**Woodhill Design and Build
Dragonfly Paddock
Eastergate Lane
Walberton**

Your Ref :
Our Ref : AW/205/17/NMA

Application for a non-material amendment following a grant of planning permission AW/70/17/HH relating to alterations in width to the permitted garage extension
4 Cherry Close, Aldwick, ,

Drawing title:-
GRG ELEV 02

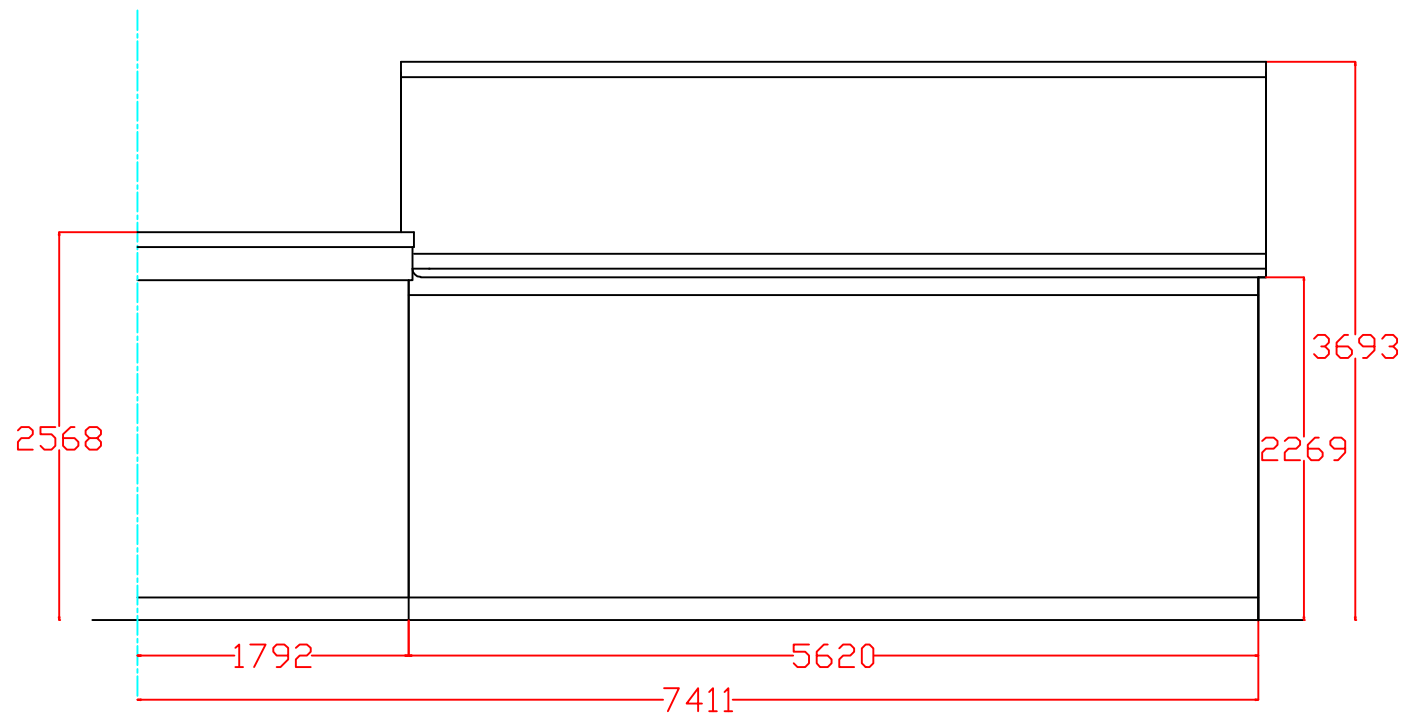
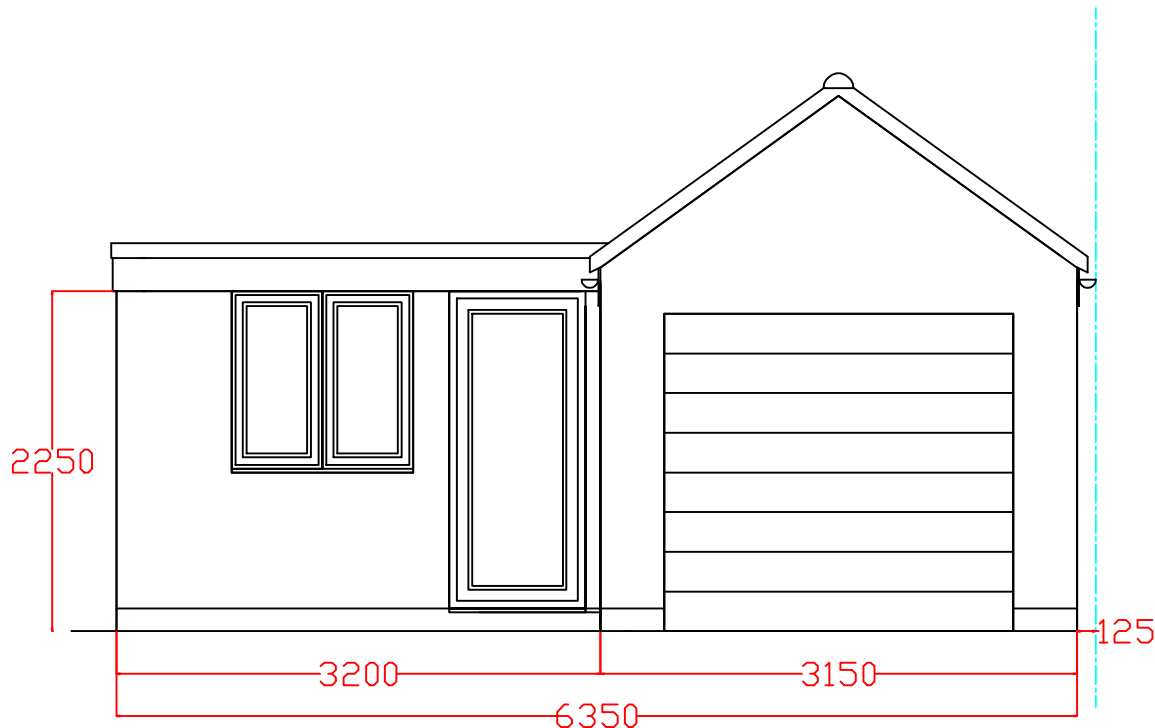
I refer to your recent application for a Non Material Minor Amendment. From the information submitted, I understand that you wish to slightly increase the width of the garage (by approximately 0.2m), slightly increase the width of the extension off the rear of the garage (by 0.2m from 5.955m to 6.150m) and slightly increase the depth of the extension off the rear of the garage (from 1.792m to 1.810m)

I do not consider that the changes will affect any neighbouring properties and therefore can be accepted as non-material minor amendments to the approved scheme. These approved changes are identified on the following drawings:
